ARUN DISTRICT COUNCIL

Reference Planning Application P/51/13.

For 9, Shirley Close, Pagham.

Regarding the above planning application, I would like to ask that the new replacement garage should have a flat roof of similar height to the existing garage, and not the high pitch roof shown on the applicants drawings.

Garage Roof Plan at 1:100 scale

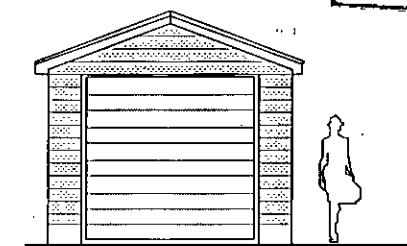
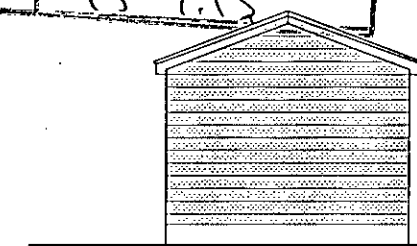
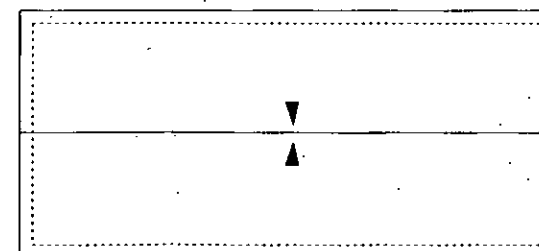
The original garage has an overall height of about 2.13 metres, whilst the new garage appears to have a height to the roof peak of 3.66 metres. Not only will this increase of over 1.5 metres (or nearly 5 feet) have a great visual impact, but it will also noticeably reduce the amount of winter sun reaching my home and garden.
